**Consultation Response from KC,
Highways Development Management**

2024/91199 140A, Manchester Road, Longroyd Bridge, Huddersfield, HD1 3JA

**Demolition of existing building and erection of student accommodation with ancillary spaces,
associated garden area, store and landscaping, access and car parking**

Date Responded: 13/08/2024

SITE PLAN Scale 1:100 0 5m 10m

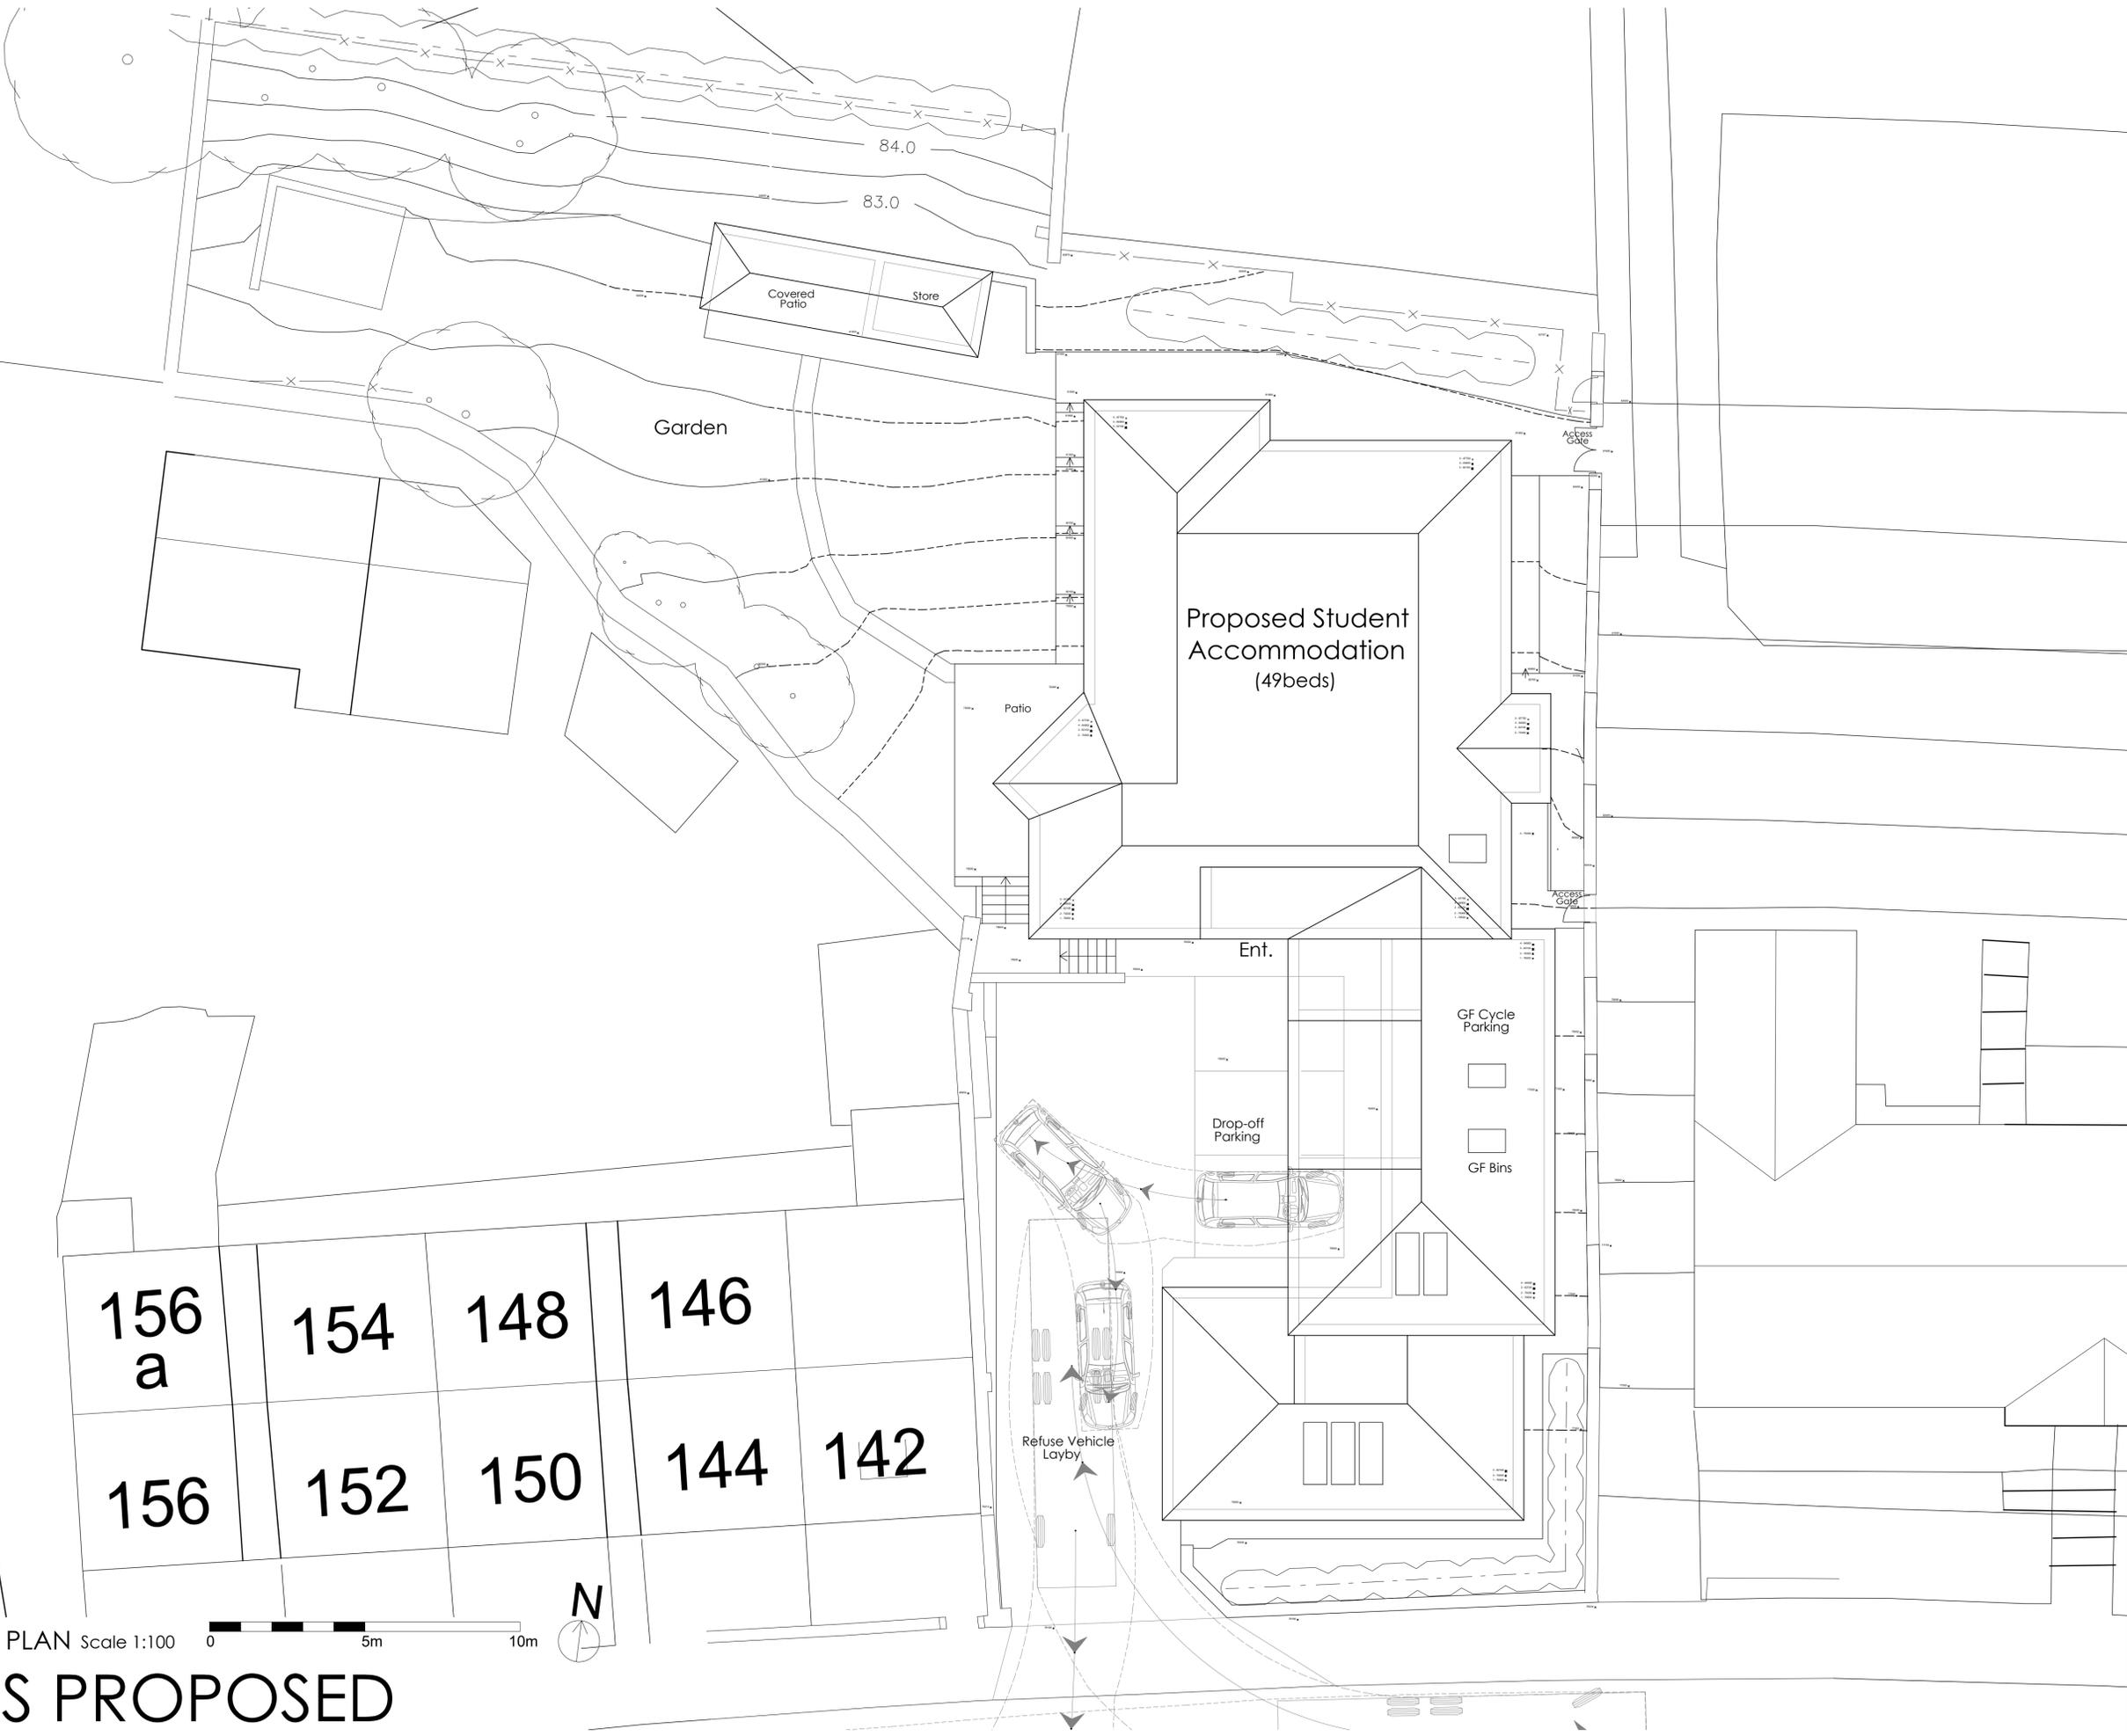
There is currently a parking area to the front of the existing building with an existing dropped crossing and the proposals are to narrow this access and this may require either a kerbed junction or narrowing of the existing dropped kerb with reinstatement of the full kerb, full details of the proposed changes to the access will be required. The new access would need to be done under the correct legal agreement with the council as Highway Authority.

No visibility splays were provided with the proposed access, however, based on maps, we consider that a splay of 2.4m x 43m is achievable, however we would need to see this indicated clearly on a drawing.

The development proposes 3 car parking spaces and 40 cycle storage spaces. The three car parking spaces measure approximately 2.4m x 4.8m, it is noted that there are support pillars that may narrow the centre parking space, however these sizes are at standards. Drawing No 23-003 Rev C show a swept path analysis showing that cars can exit the parking spaces so they can enter and exit the site in forward gear for highway safety reasons. However, the drawing only shows a swept path for the southernmost (most accessible) space and not for the remaining two. We consider that the middle space should also allow for a car to turn, although this may be more difficult due to the narrowing caused by the support pillars, however we do not consider that the northernmost parking space has sufficient manoeuvring space to allow a car to turn to enter and exit in forward gear, especially if the other parking spaces are occupied. Due to this we feel that this space will not be attractive to drivers and therefore will not be

used or will cause drivers to reverse out on to A62 Manchester Road, which would be a highway safety concern. Due to this we feel that the design only offers two usable car parking spaces. This may be acceptable as general day to day parking can be managed, with the occupants being advised to use sustainable or active travel modes. However, a problem is expected to arise on start/end of term drop-off and pick-up.
